Application for a Non-Material Amendment Following a Grant of Planning Permission

Non-Material Amendment(s) Sought

Title:
Proposed Side Extension
Floor Plan
Option A2

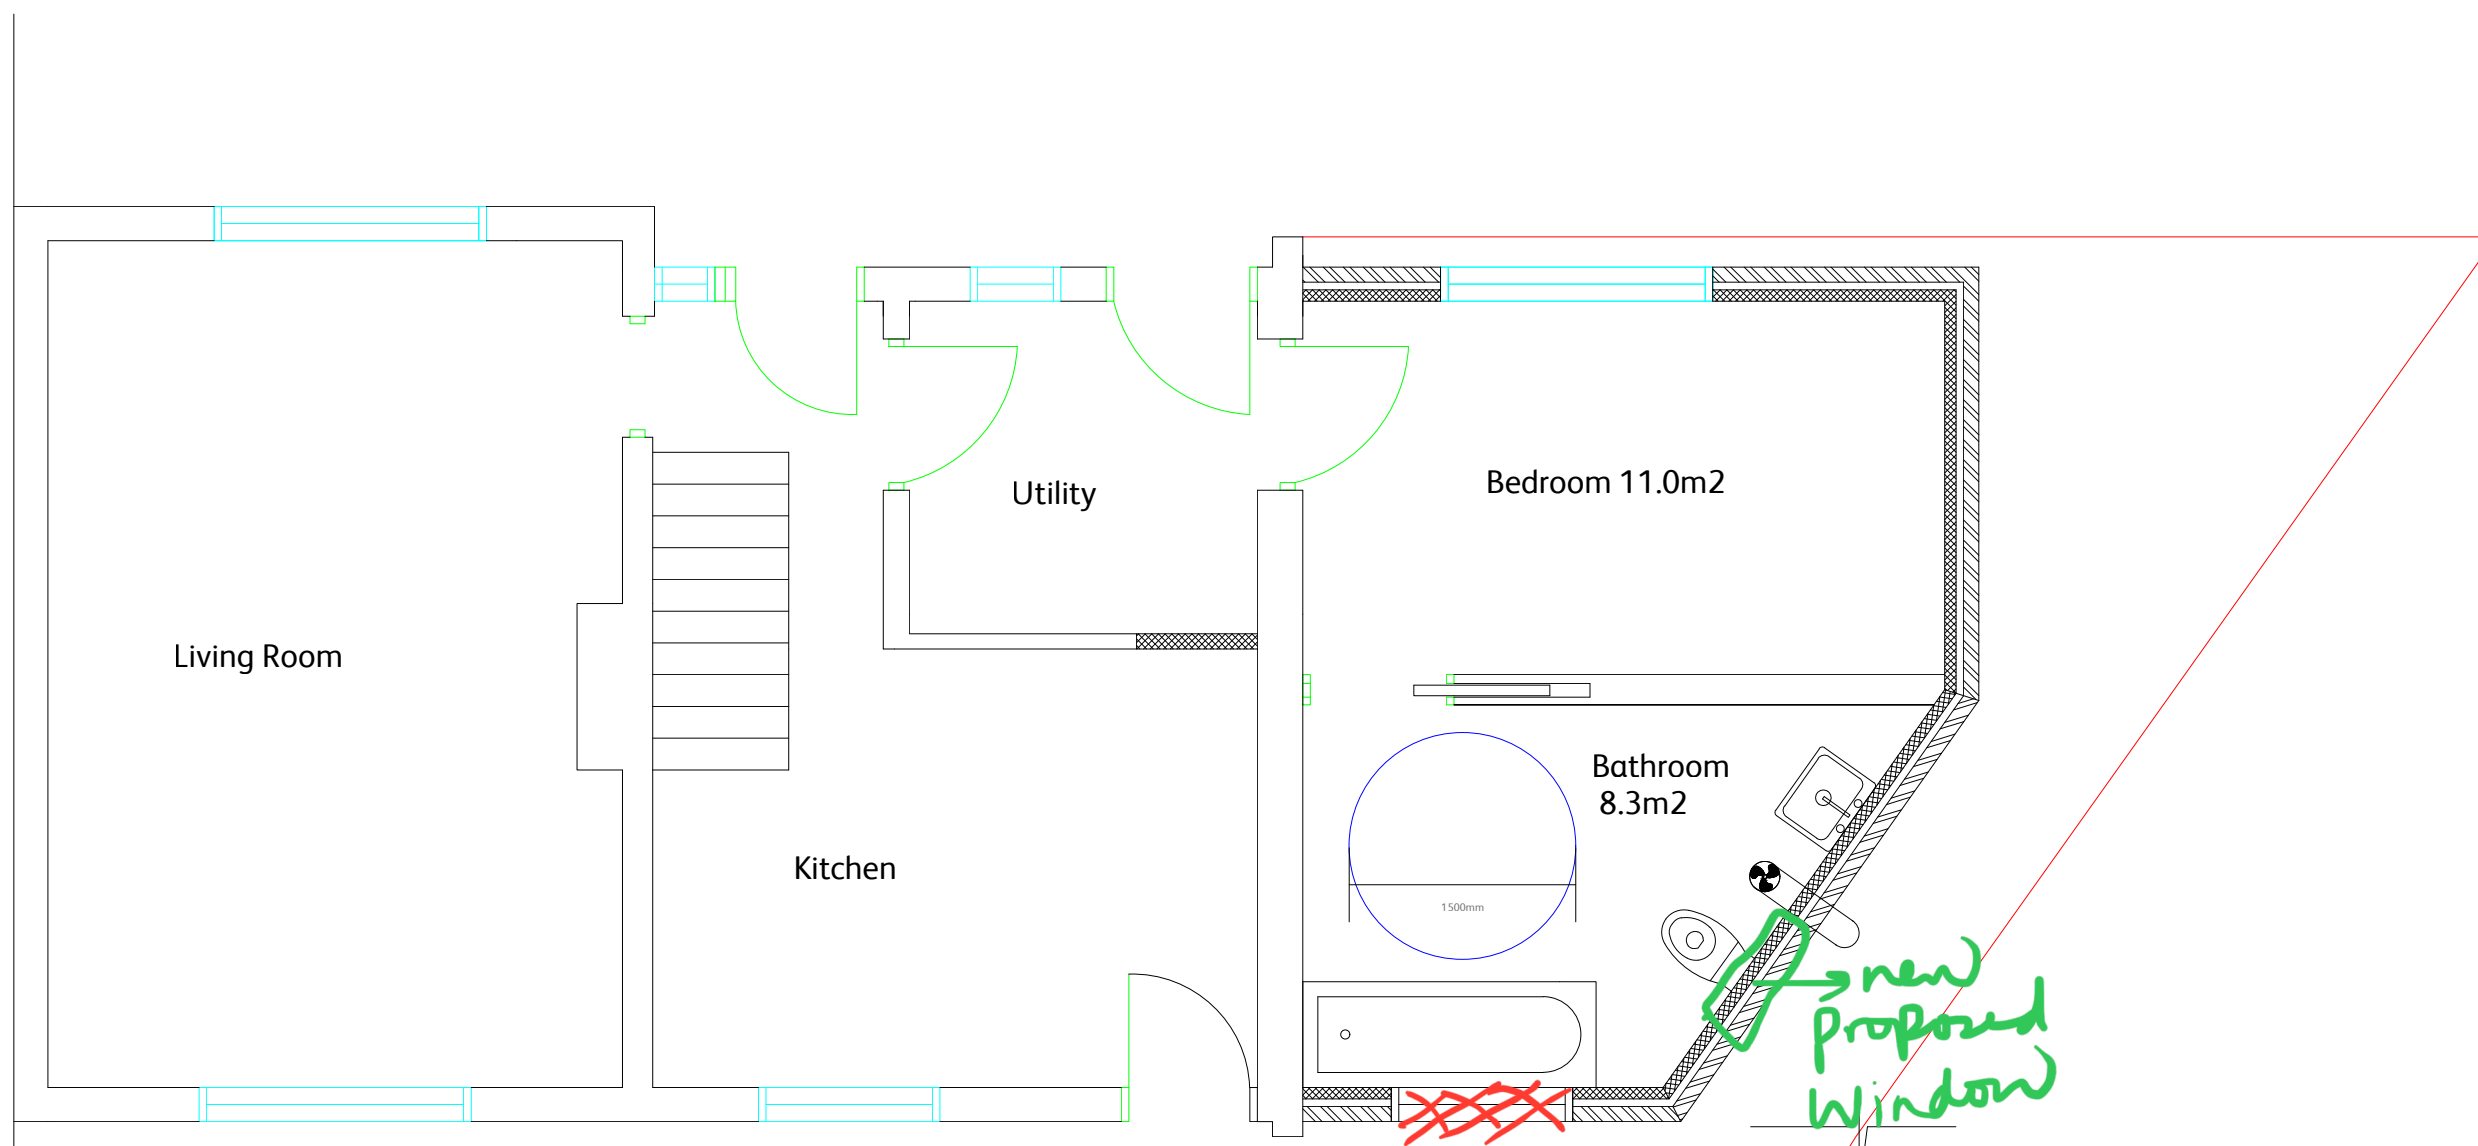
Moving the window from above the bath to the rear of the WC

Occupational Therapist has assessed the child living in the property & has remodelled the bathroom, the window to the rear of the new extension is to be moved to a new location
